18 February 2019

New Tweed Valley Hospital SSD 18_9575 – Second Supplementary Response to Submissions

Designed	PA	Project Director Approved	Date	North
Drawn	PA			
Scale	1:1250	Project Ref	Drawing No	Rev
Date	03.09.18	20 10748 01	C030	P6
Sheet	A1

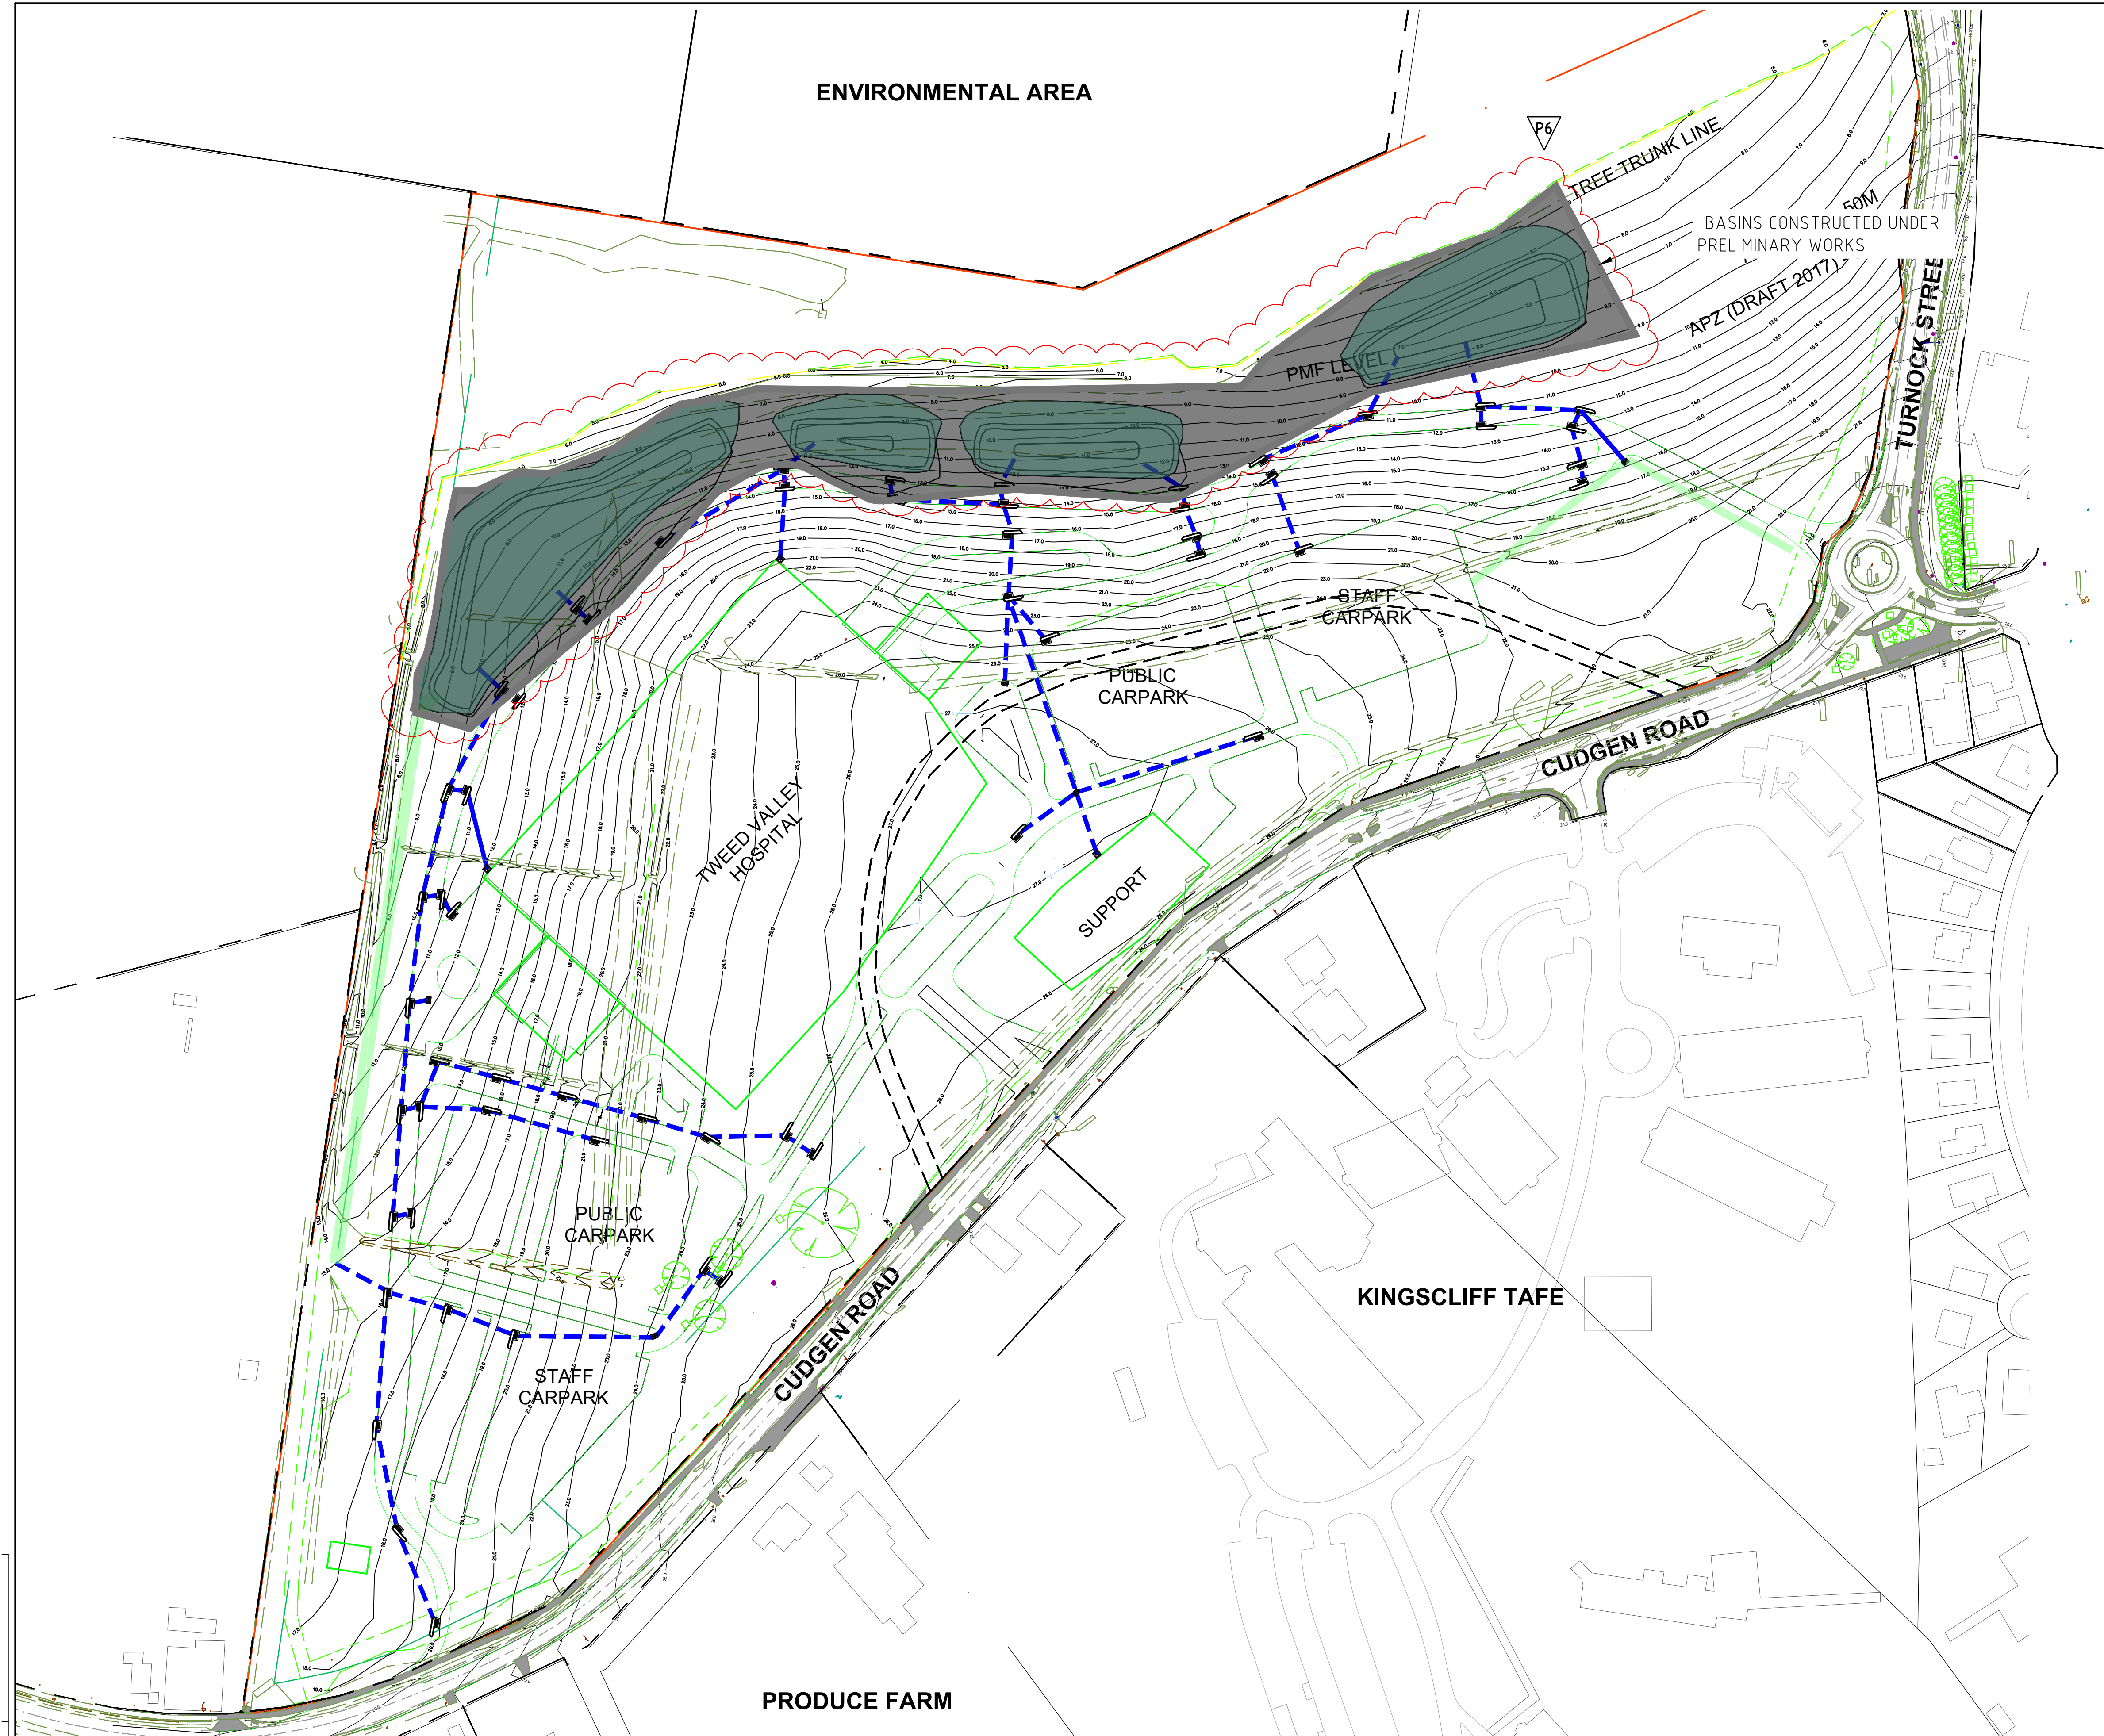
Provide a clear scope of drainage works in Concept Proposal and Stage 1

Stage 1 drainage works are limited to works required to direct stormwater from disturbed earthworks areas to the sediment basins as part of the Soil and Water Management Plan. The extent of the drainage works is shown in Bonacci Drawing C030 P6 within the final plan package. The stormwater layout for the Stage 1 works will be further documented during detail design for the Stage 1 works, as input from builder contractor on staging and methodology will be required.

File: G:\Job\1074803 Work in Progress\02 Civil\03 Sketches & Markups\1074803-SK13 190204 - RETAINING WALL OVERALL PLAN.dwg Plotted: 07/02/19 at 4:20 PM By: Jonathan Frango

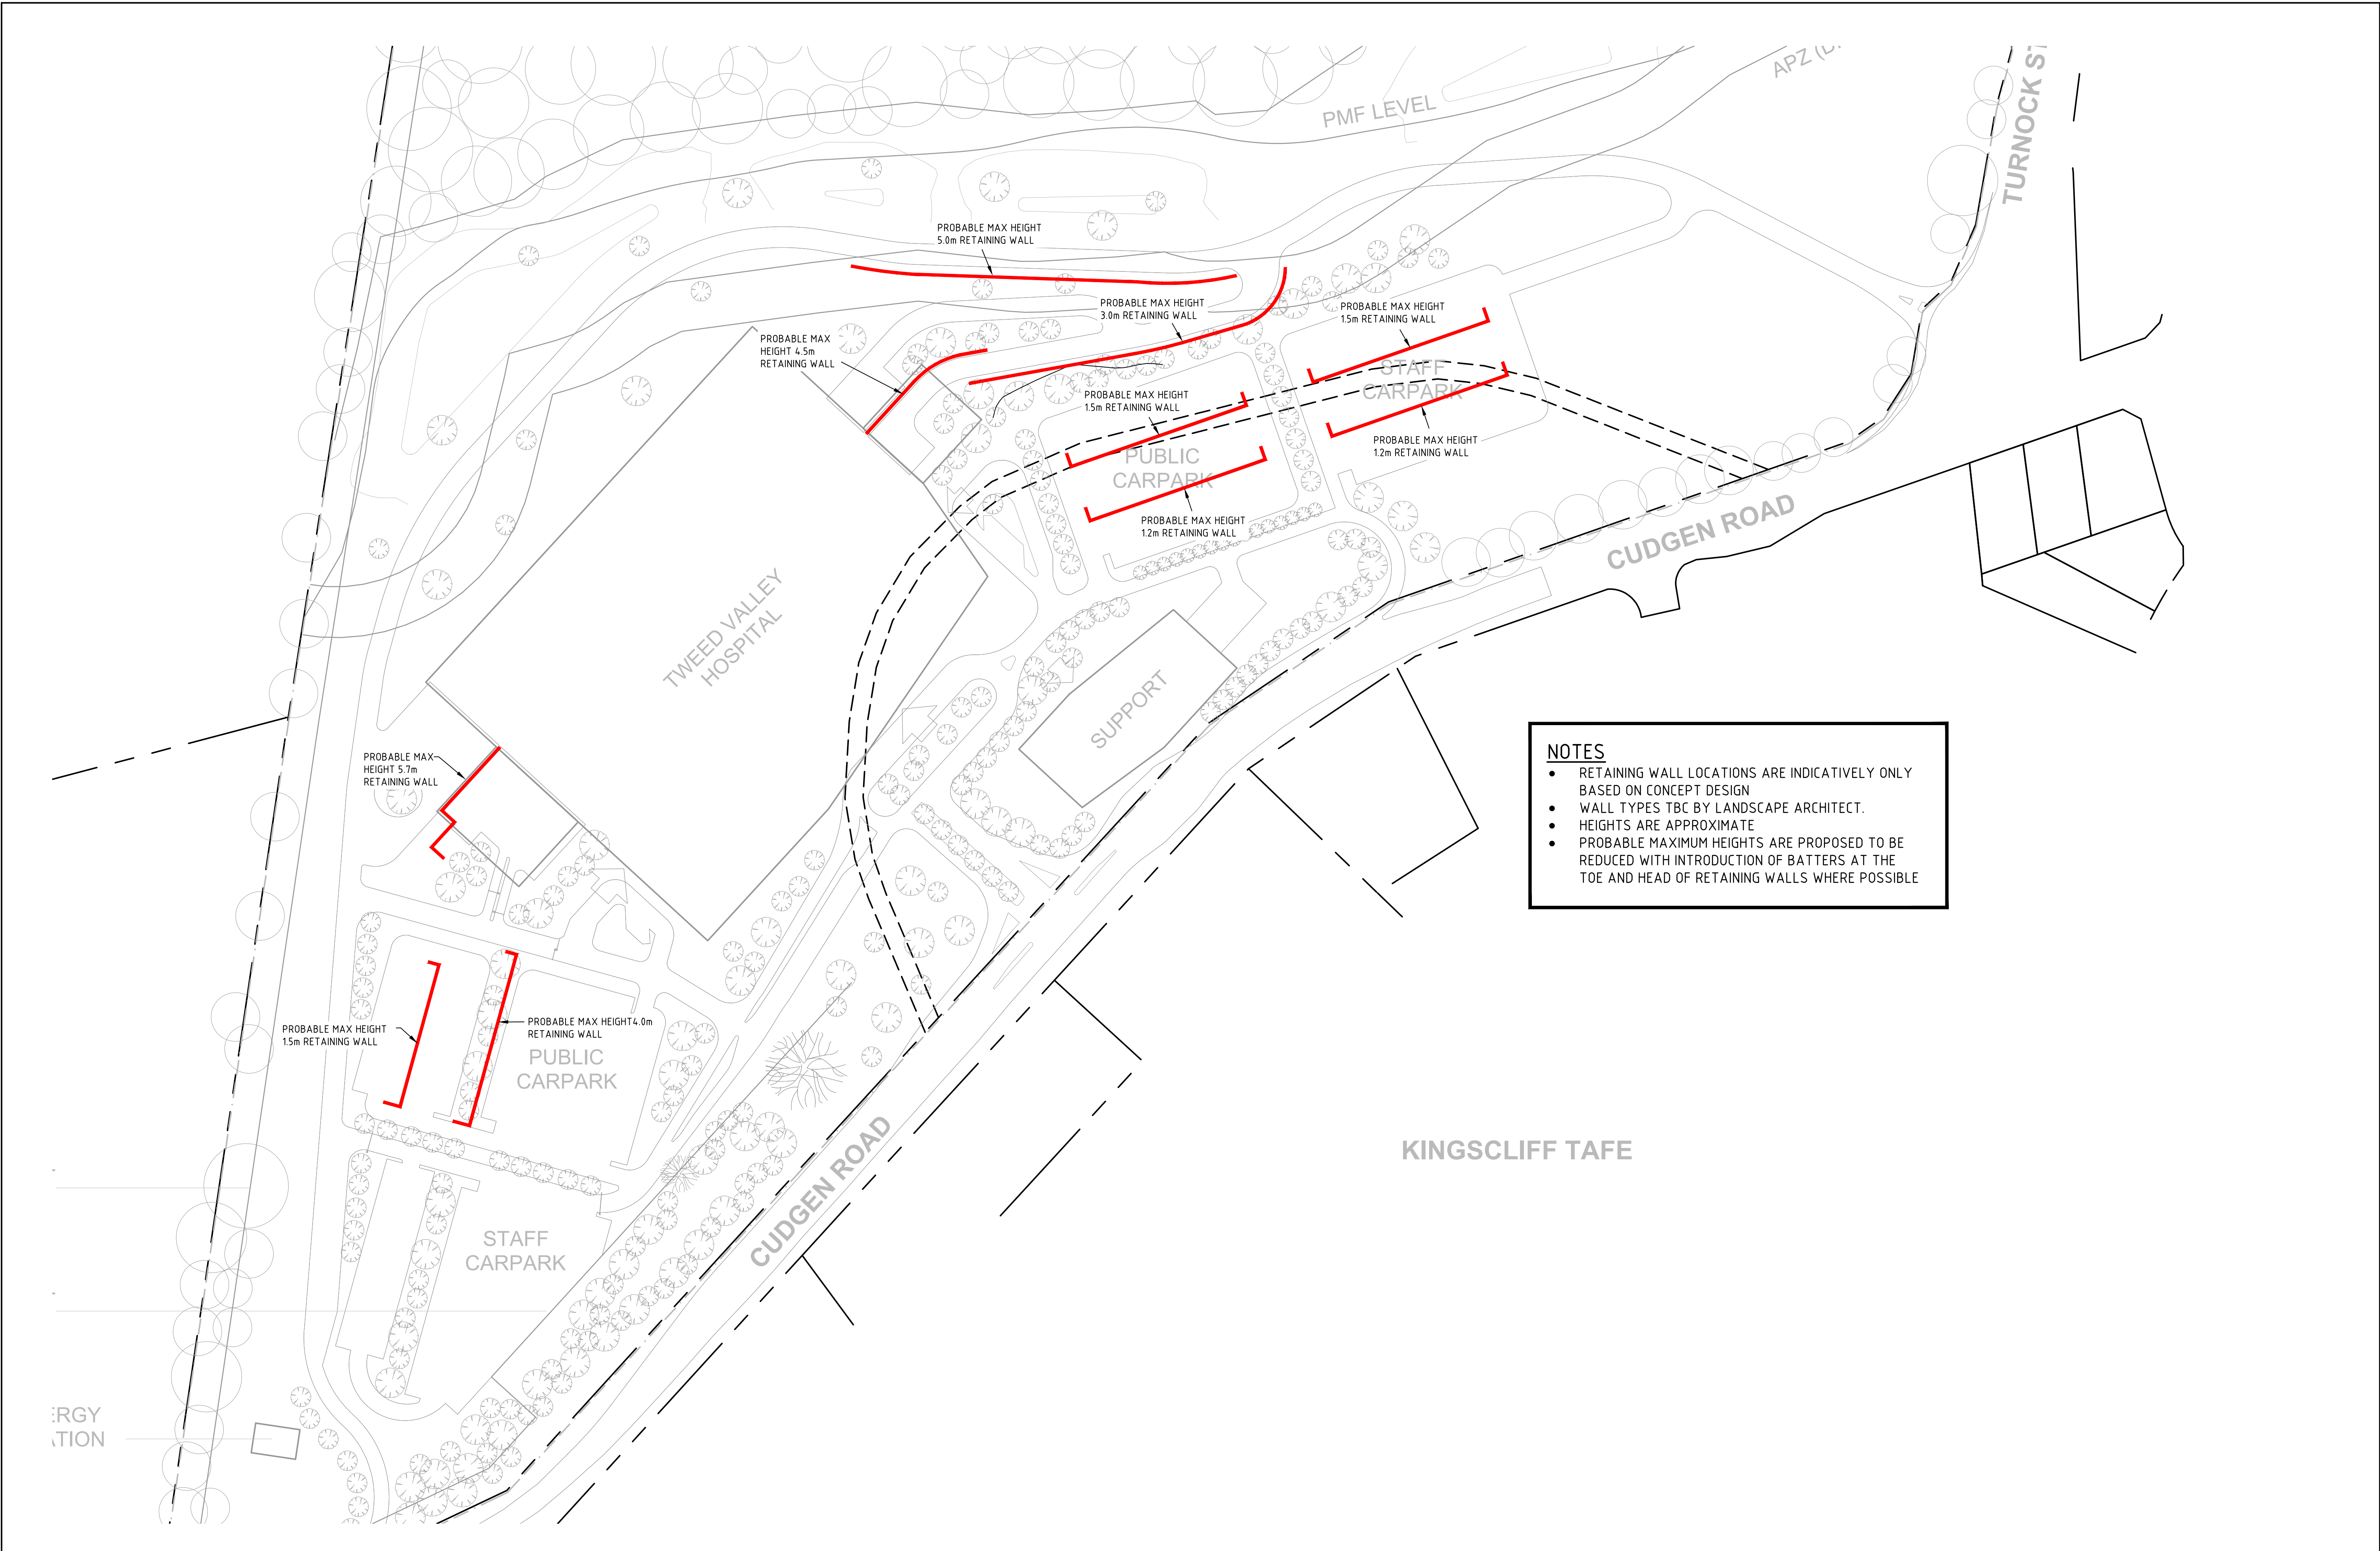
Provide further details and confirmation of the height and landscape treatment of proposed retaining walls

Bonacci has advised that the probable maximum height of retaining walls shown on Drawing no. No. SK13 Rev P1 prepared by Bonacci are approximate and subject to refinement. It is noted that the highest retaining wall shown on this plan has a probable height of 5.7m. However, the design intent is to reduce the probable maximum heights of all retaining walls to under 3.4m by introducing batters at the toe and head of the retaining walls where feasible.

The visual impact of retaining walls on the surrounding properties will be mitigated using a combination of techniques. Banking of landscape areas to the top and toe of walls (at appropriate maximum grades), will minimize total wall heights. Walls will also be terraced where possible to further reduce bulk and scale. The materiality and texture of walling will also be carefully considered to mitigate visual impact. Gabion walling is currently being considered, using local natural stone with hues that complement the natural landscape, and reference the local historic stone wall construction by South Sea Islanders. The walls will then be masked with vegetation. Generous zones of planting will be provided to the foot of retaining walls wherever possible, and cascading planting to the top of walls where appropriate.
